**From:** Simon Davis  
**Sent:** 02 December 2025 17:06  
**To:** Planning.Responses  
**Subject:** FW: Land at West Barn, Old Dairy Lane - AL/107/25/PL (SUB PLAN REQUEST)  
**Attachments:** 25-01-04 Block and Location Plan Rev E.pdf

**From:** Kate Chapman [REDACTED]  
**Sent:** 02 December 2025 16:16  
**To:** Simon Davis <[Simon.Davis@arun.gov.uk](mailto:Simon.Davis@arun.gov.uk)>  
**Subject:** RE: Land at West Barn, Old Dairy Lane - AL/107/25/PL

CLIENT BioDot		
PROJECT New office building adjacent to West Barn Norton Lane, Norton, Aldingbourne		
DRAWING TITLE Block Plan and Location Plan		
DATE Feb 2025	SCALE As shown	DRAWN BY CHECKED BY
JOB NO. 25 / 01	DRAWING NO. 04	REVISION Rev E

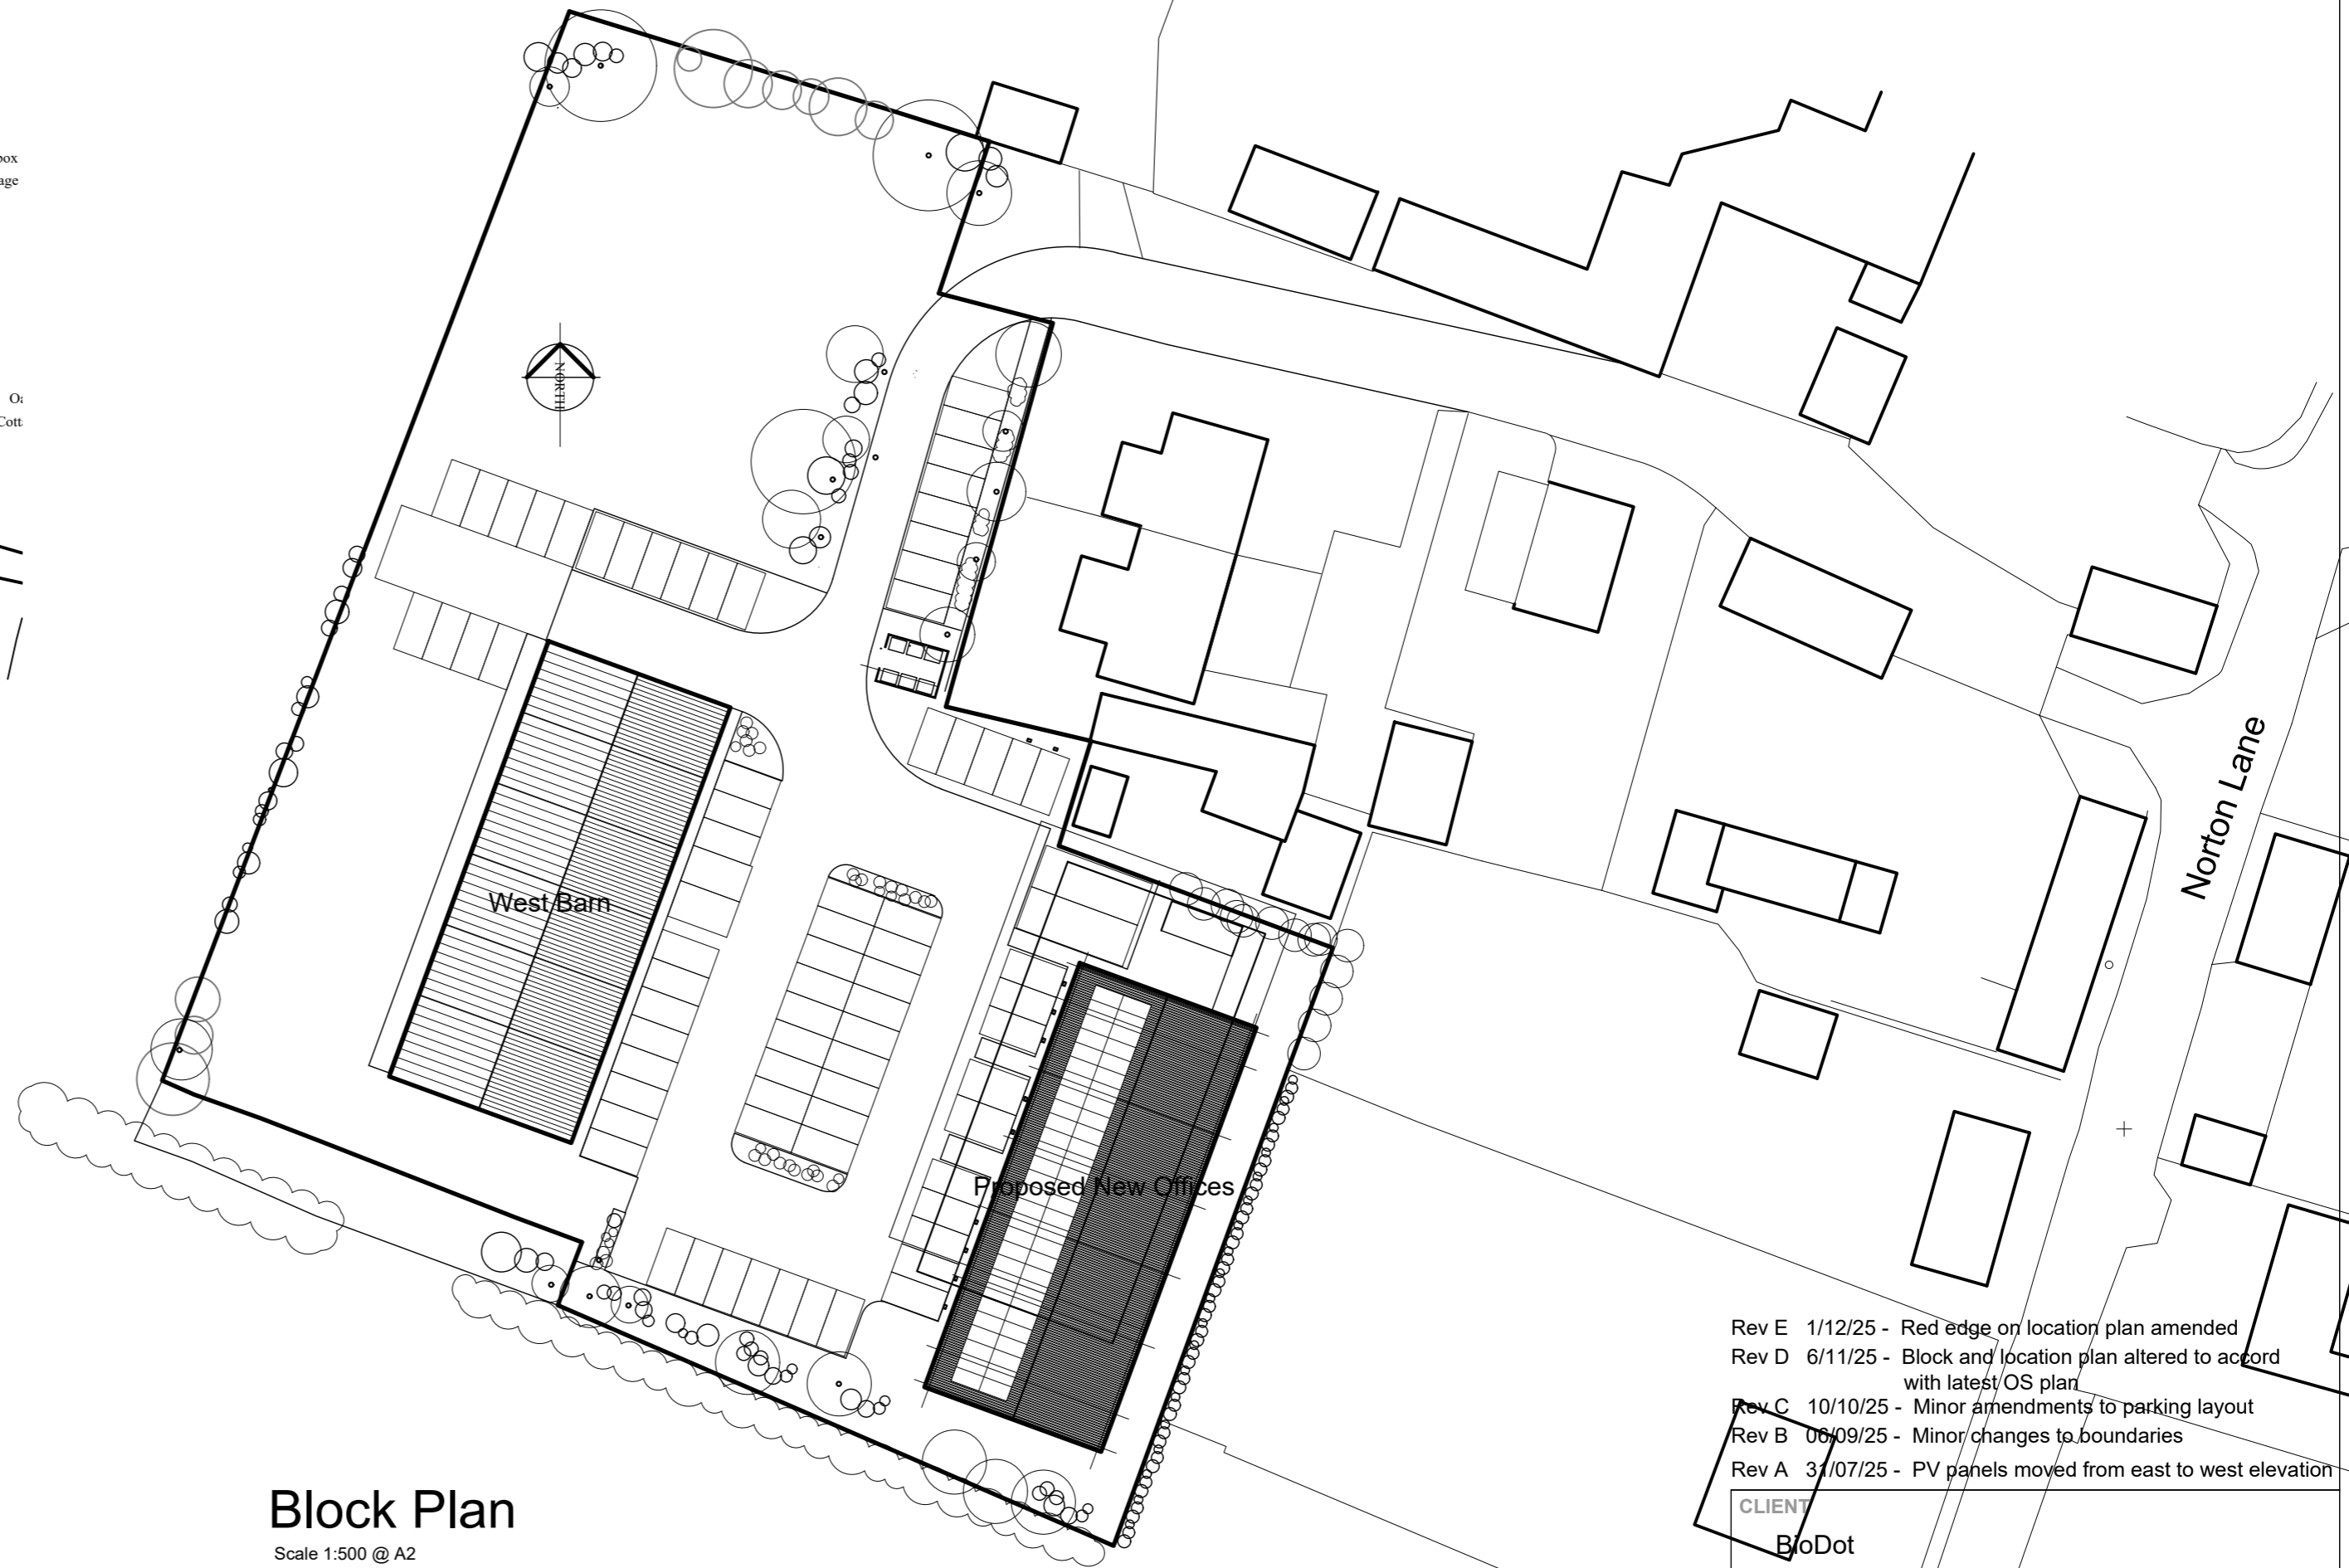
Further to the changes you made to the location and block plans, it has been brought to my attention that your red edge drawing suggests that land is part of Old Dairy Lane when in fact it is parking to East Barn (East Barn is not marked on the below but is directly above The Hovel and borders Old Dairy Lane). The below is a LR plan I have seen sent on the left and your red edge plan on the right. I have also been sent the attached purporting to show your clients ownership in yellow. I say purporting because I don't have access to the LR title deeds etc. to check this myself.

If the red edge has indeed been shown to include land not in your client's ownership, then can you either amend the red edge or serve notice on the owners of the land.

Further to your email regarding the red edge, this has now been updated removing the slither of land in question. Please find attached updated;

Block plan and Location Plan Dwg No.04 Rev E
